KITTTITAS COUNTY COMMUNITY DEVELOPMENT SERVICES

RE: *Spirit Wind Farms Boundary Line Adjustment (BL-14-00012)*

In order for the County to continue processing this application, additional information is required. The following information is due to the County by March 3, 2015:

*Existing Parcel Configuration
 (Unified Site Plan)*

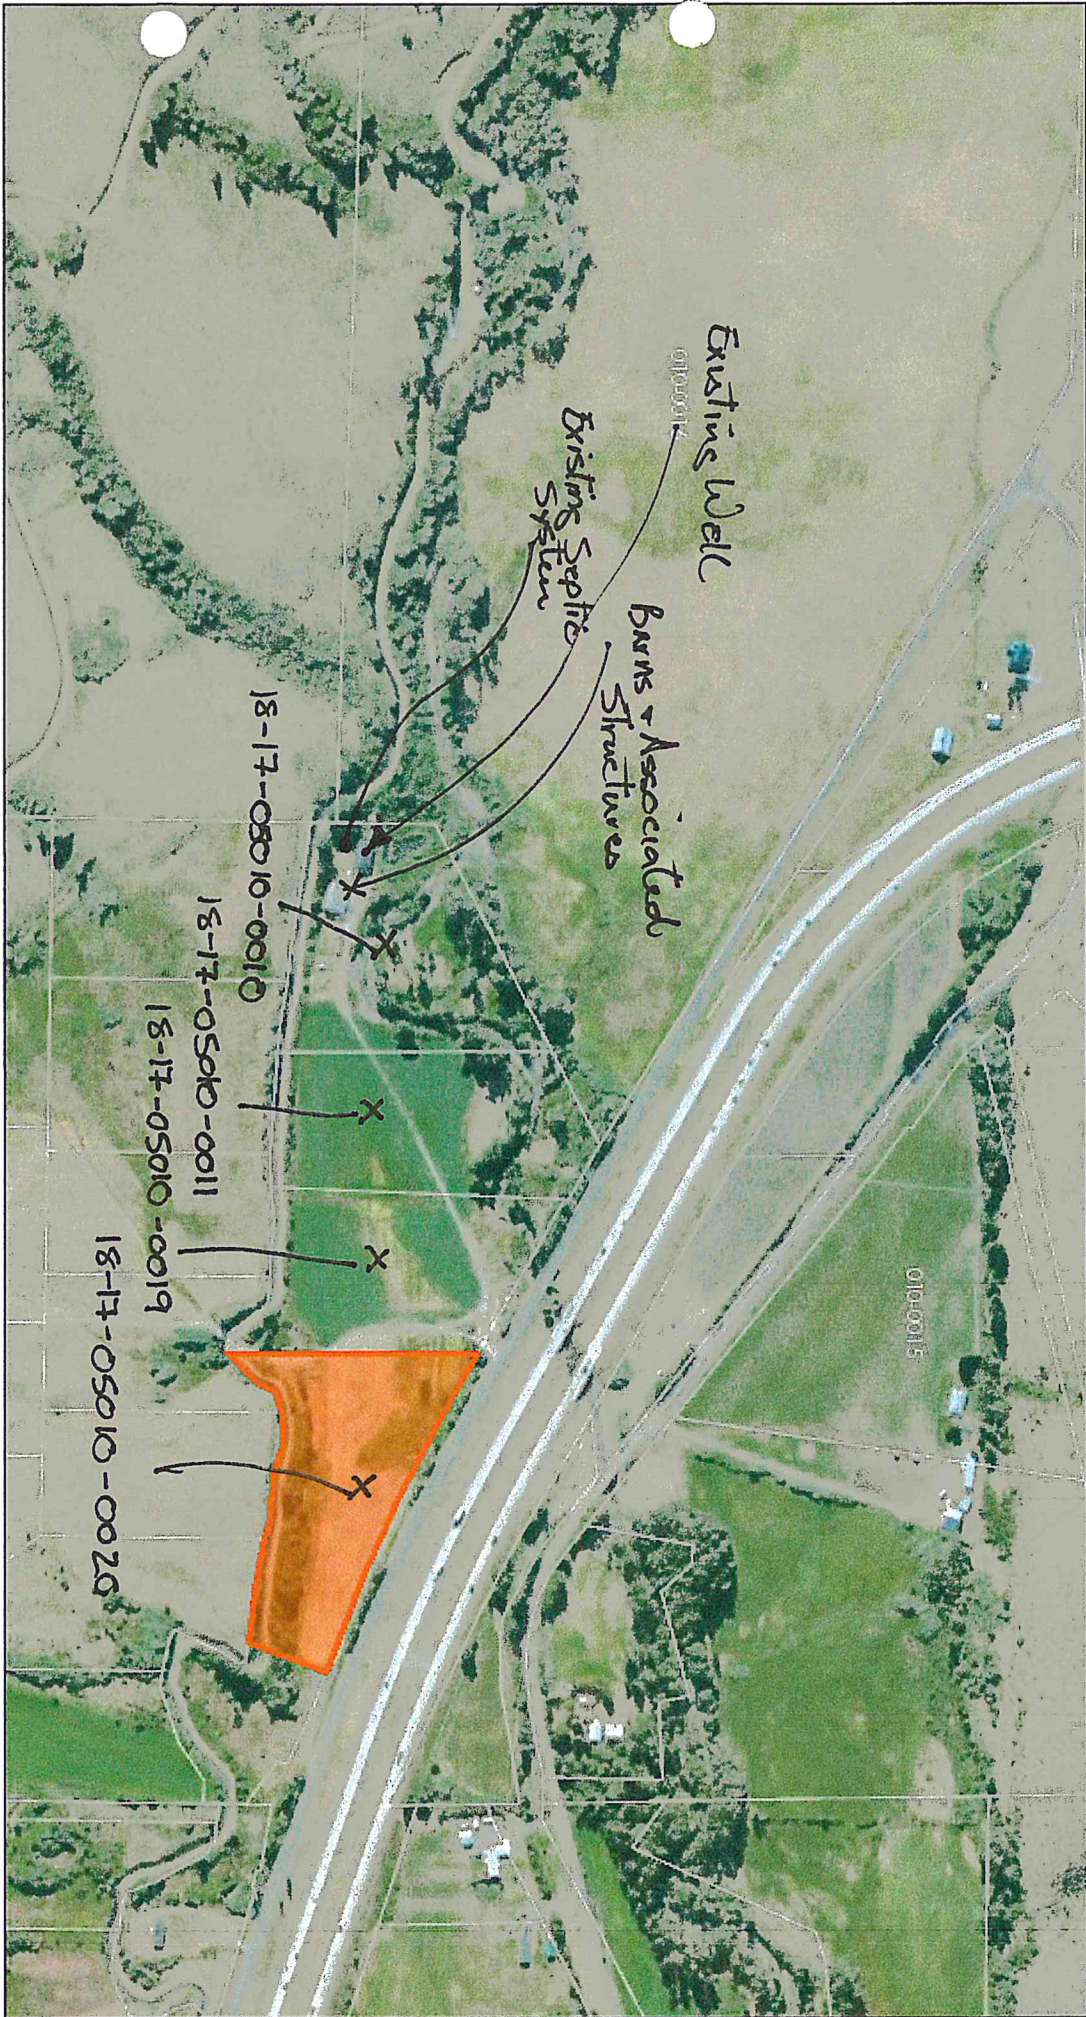
- **One site plan of the *existing* lot lines with all wells and septic fields identified.**
- **One site plan of the *propose* lot lines with all wells and septic fields identified.**
